**KIRKLEES METROPOLITAN COUNCIL
INVESTMENT & REGENERATION SERVICE**

Reference No: 2021/62/92068/W

Site Address: 7, Fenay Crescent, Almondbury, Huddersfield, HD5 8XY

Description: Erection of two storey side and rear extensions and single storey front extensions (modified proposal)

PROPOSED 1ST FLOOR PLAN

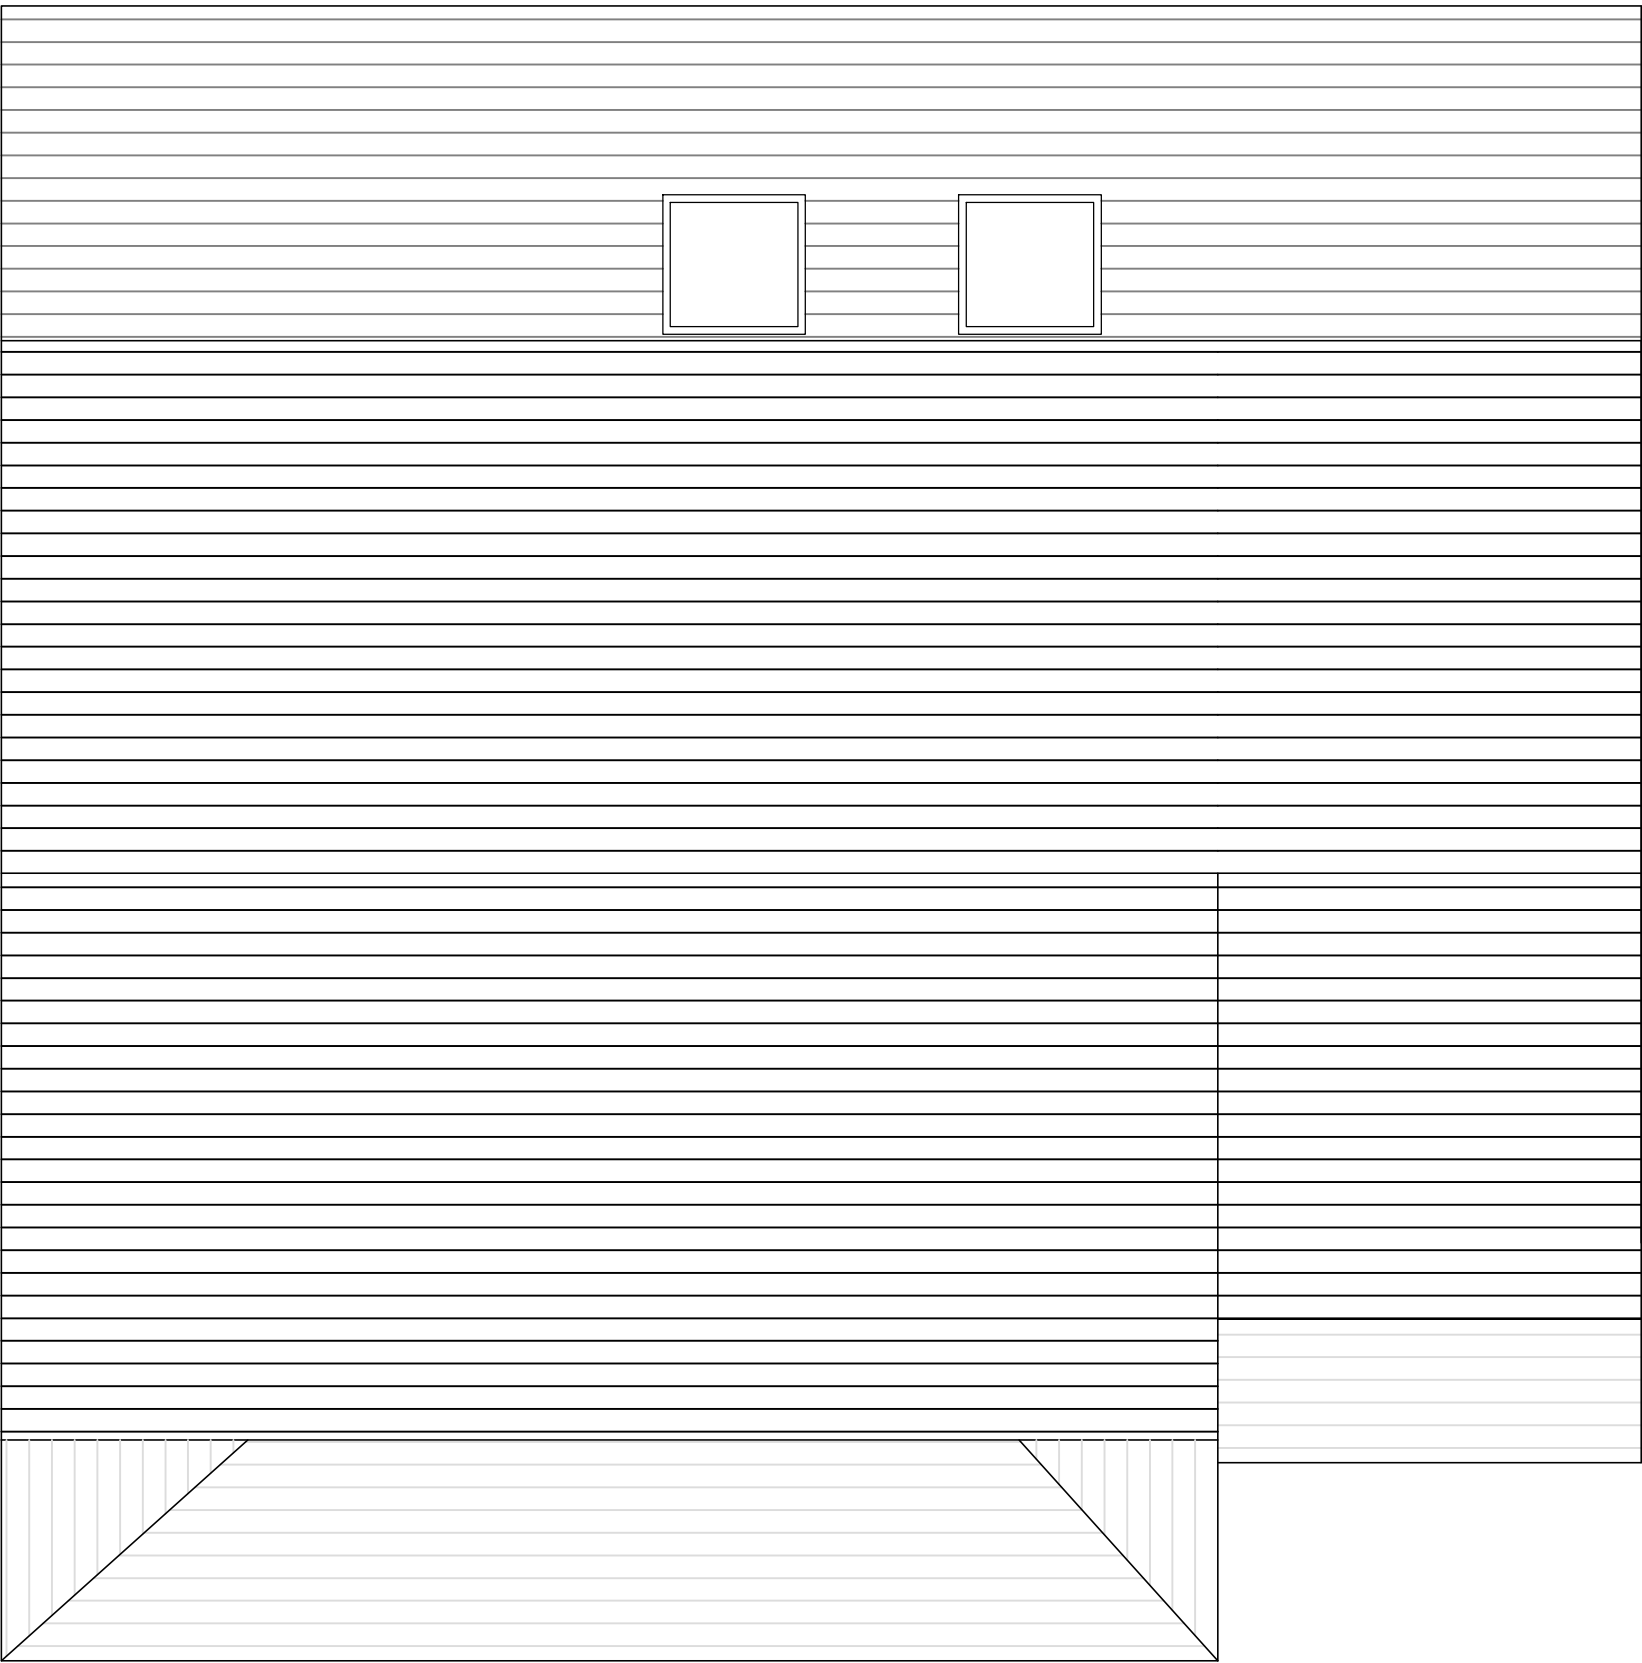
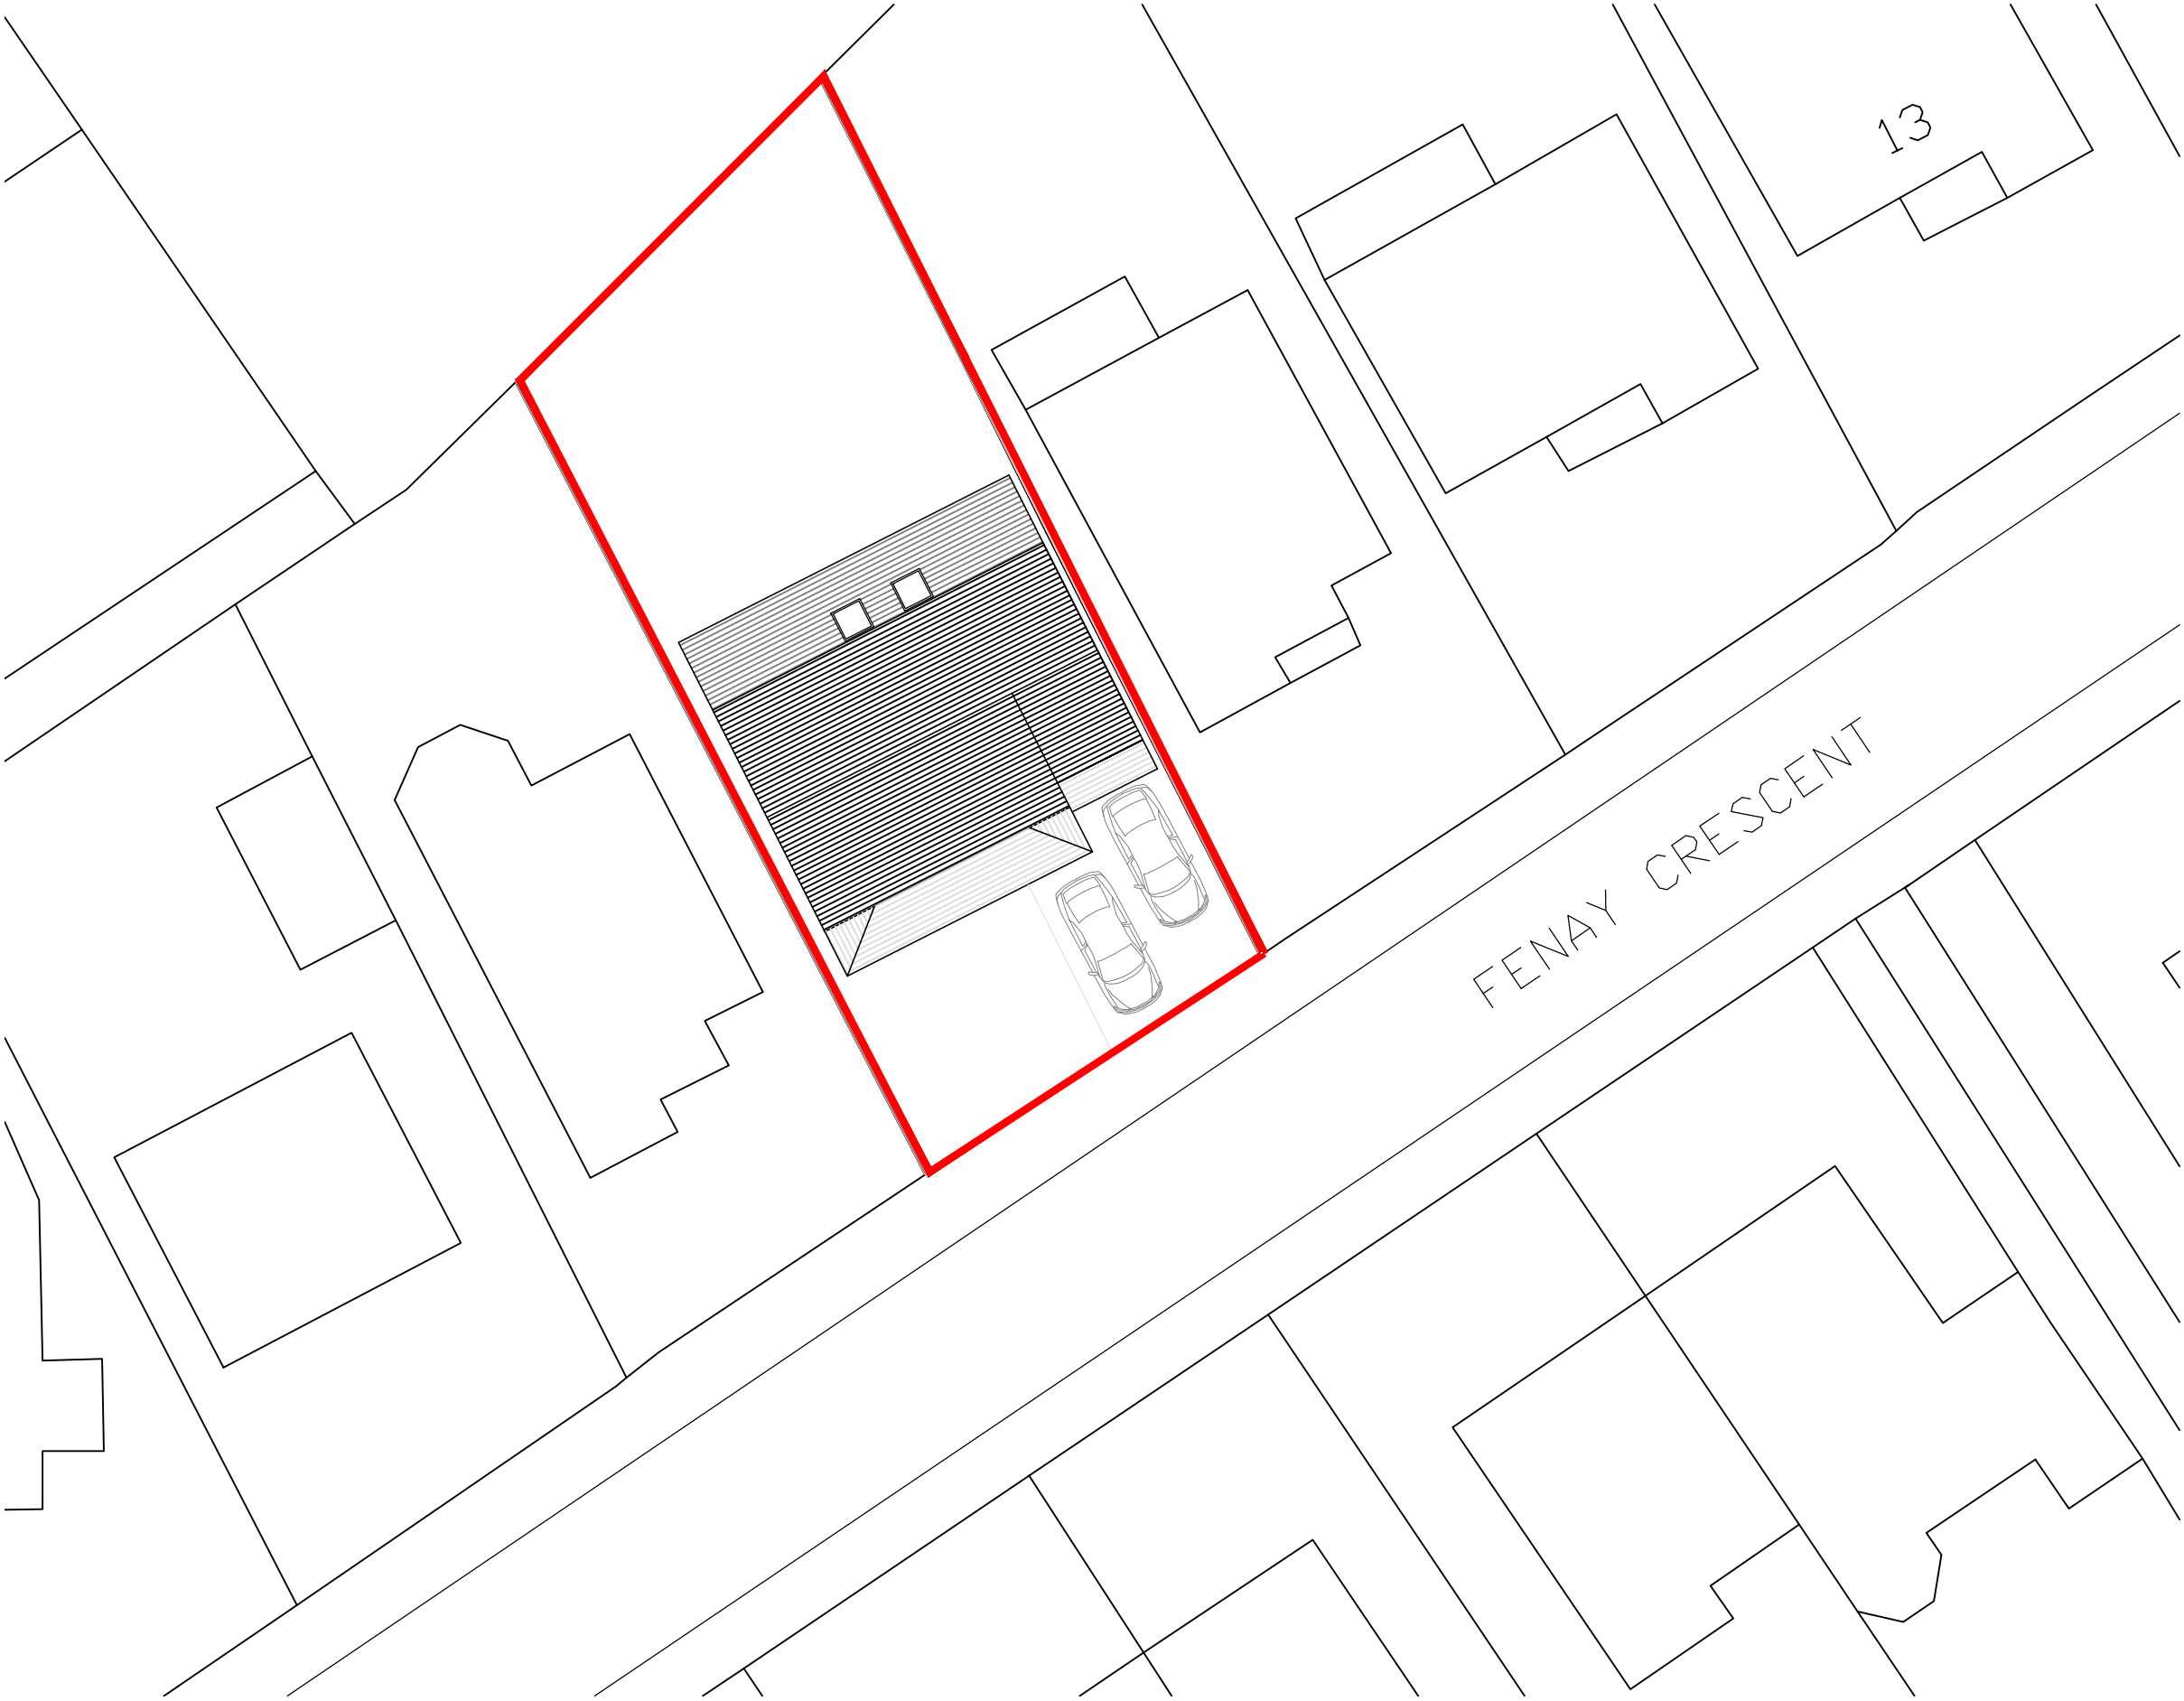
In terms of highway safety, the new garage would have internal measurements of 2.4m wide by 5m long which is narrow but would accommodate a small car, the remaining drive would be approx. 6m long, again could accommodate one car. The agent has submitted an amended plan to create a second space to the front given the reduced internal measurements of the garage, as such would meet the aims of Policy LP22 of the Kirklees Local Plan with respect to highway safety and advice in Chapter 12 of the National Planning Policy Framework.

4. The proposed additional parking space detailed on Dwg. No. (20) 002 shall be provided at the front of the property before the development is first brought into use and thereafter retained, all areas indicated to be used for parking on the submitted plans shall be finished in a hardened and drained surface in accordance with the Communities and Local Government; and Environment Agencies 'Guidance on the permeable surfacing of front gardens (parking areas)' published 13th May 2009 (ISBN 9781409804864) as amended or any successor guidance. Notwithstanding the provisions of the Town and Country Planning (General Permitted Development) Order 2015 as amended (or any Order revoking or re-enacting that Order) these areas shall be so retained, free of obstructions and available for the use specified on the submitted plans.
